Planning
Arun District Council
Town Hall
Clarence Road
West Sussex
PO21 1LD

Re: BE/87/21/OUT

Nursery Fields, Land to the North of Chalcraft Lane, West Bersted, PO21 5TS

Outline application with some matters reserved to provide up to 225 residential units with associated infrastructure, open space and vehicular and pedestrian access.

APPENDIX 5
SITE ACCESS PLAN (REF: ITB14244-GA-009B)

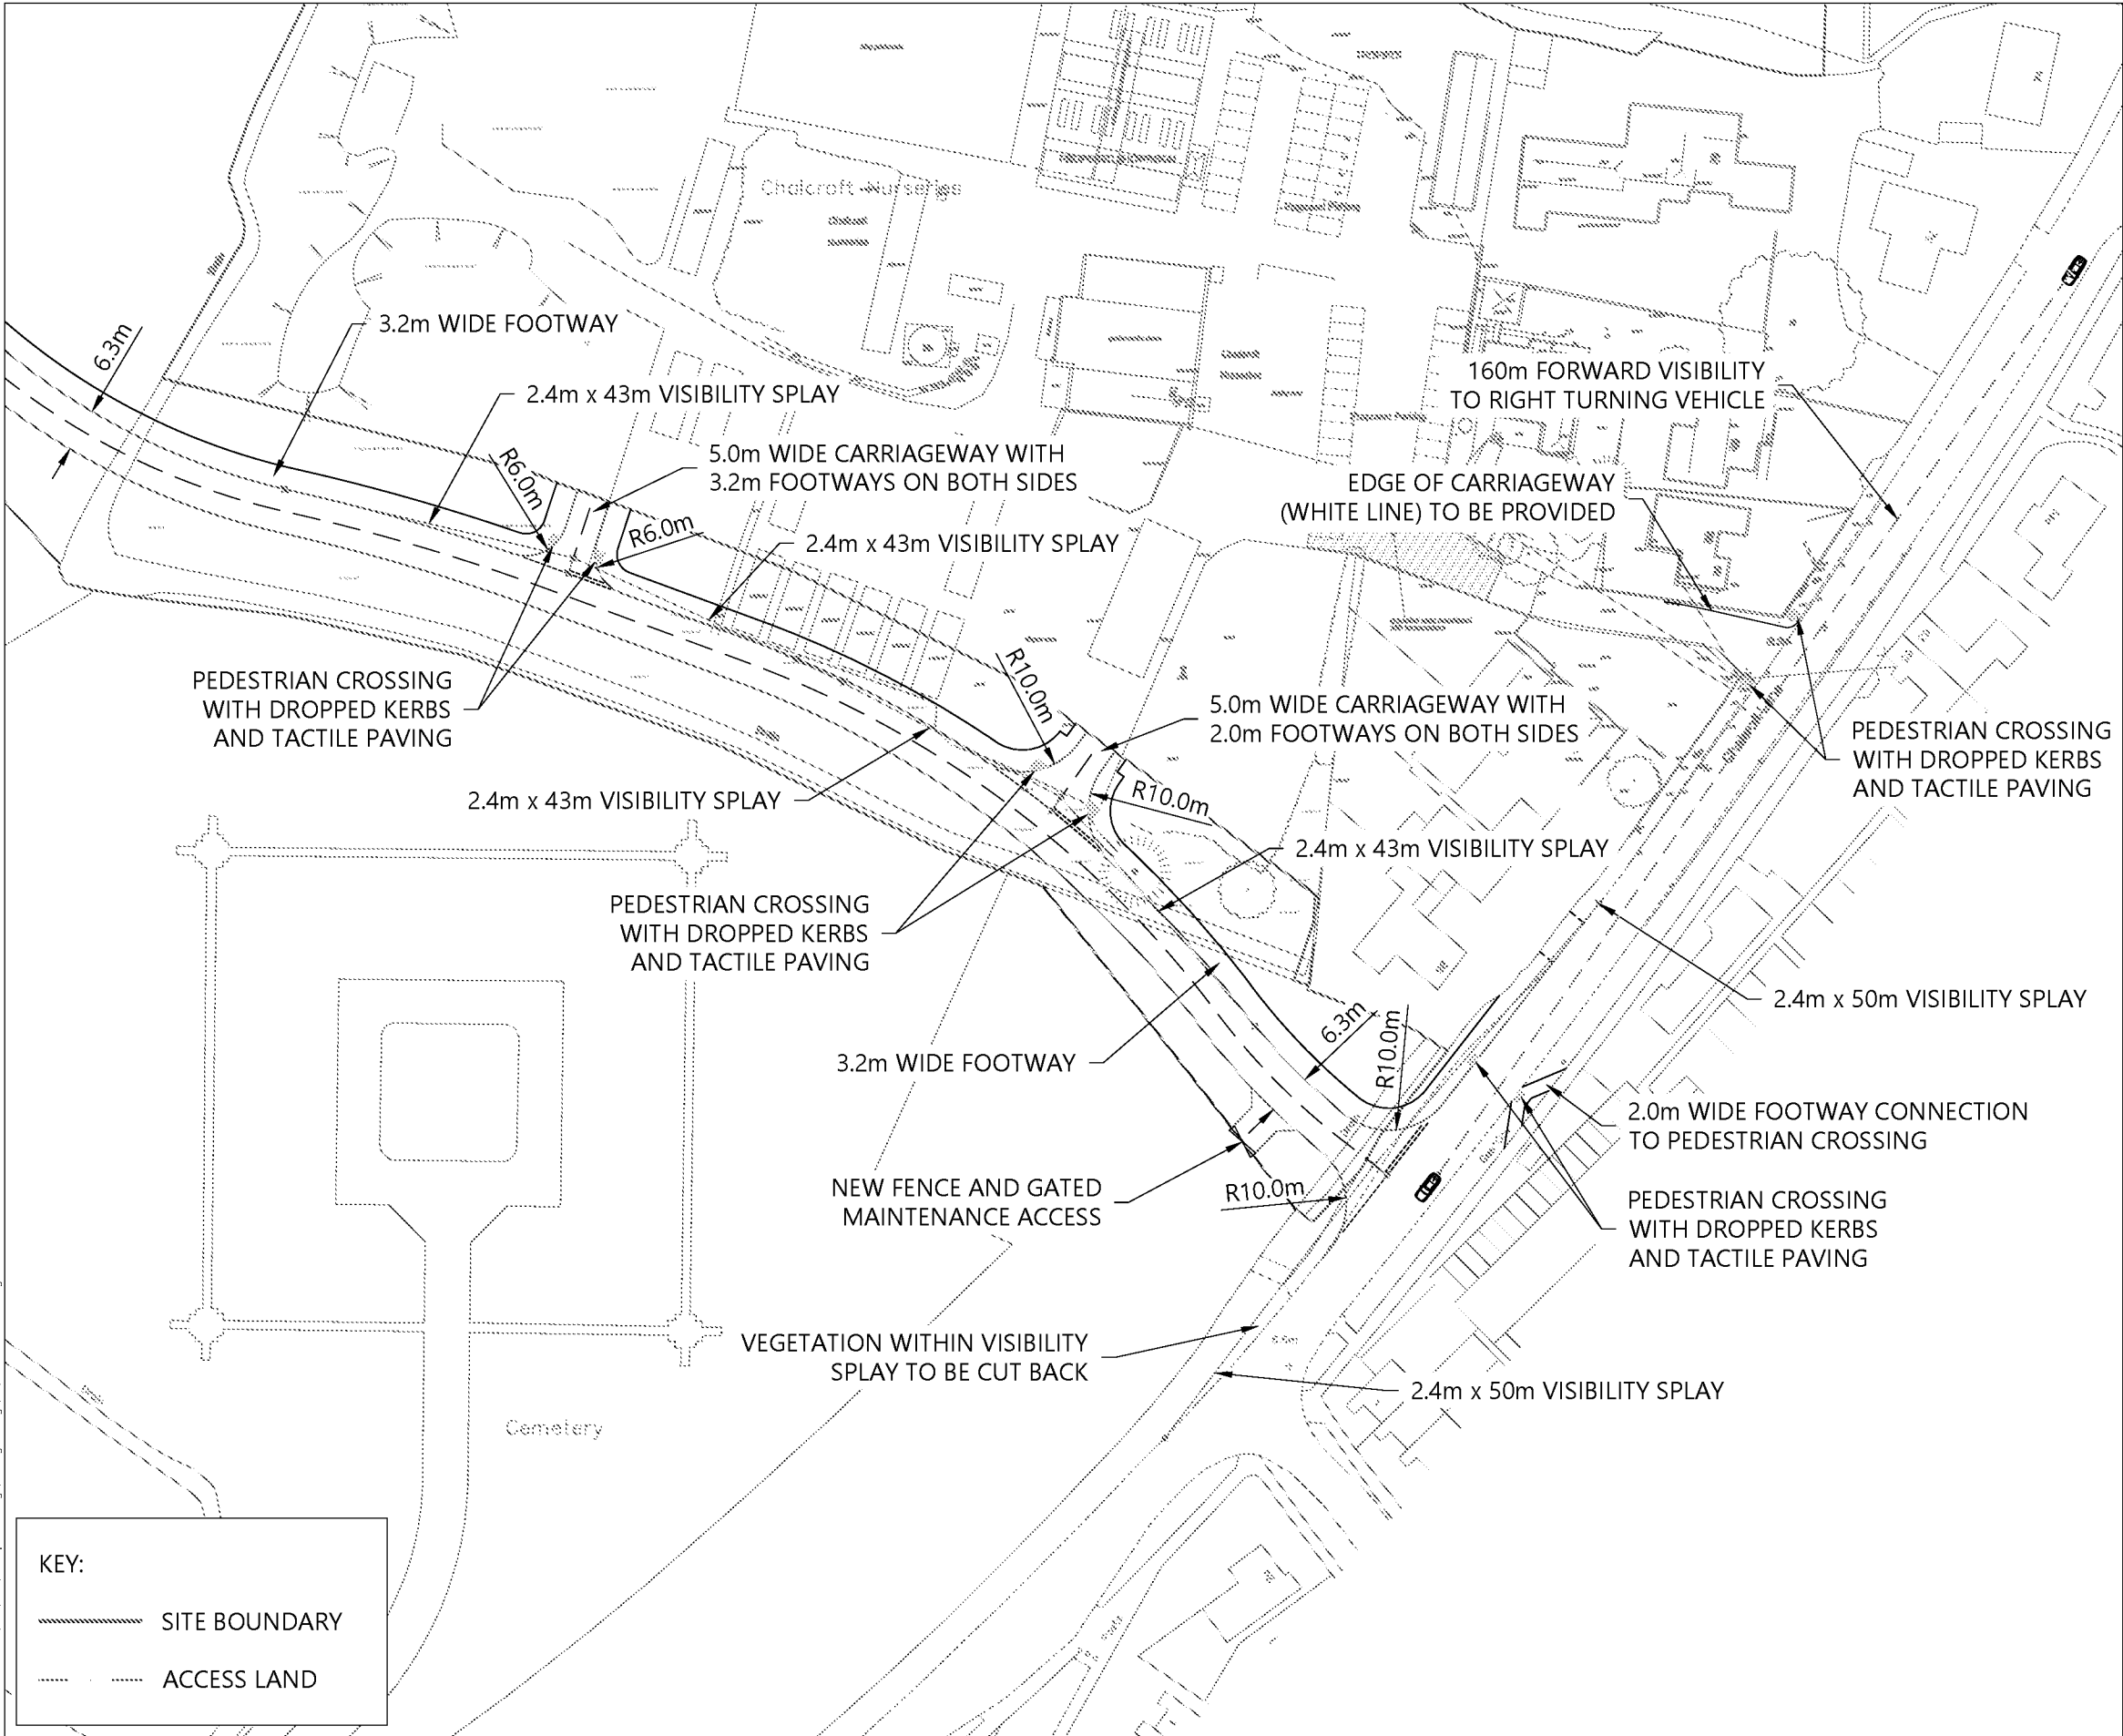
- The proposed access from Chalcraft Lane, shared with the application Chalcraft Nursery site BE/18/20/OUT, as a simple junction with no signal controls, is consistent with the West Bersted Framework Masterplan. Clarity is given in the Transport Assessment (TA) that traffic data collected in 2018 has been subject to an allowance for growth associated with committed development totalling 1,214 dwellings and 1,542 sqm of commercial development. Additionally, the TA states that whilst bus links and/or emergency vehicle access might be a future consideration for cross boundary connection, the proposed access has been designed to accommodate only the assessed vehicle numbers associated with the Nursery Fields application and that of Chalcraft Nursery BE/81/20/OUT.

- The Board notes the provision of pedestrian and cycle ways running parallel to the proposed access road.
- Given that the proposed access road is shared across two sites, the Board would encourage the applicant to work with the local planning authority and potential developers to ensure that the needs of pedestrians and cyclists are considered in the phasing of the construction cycle.
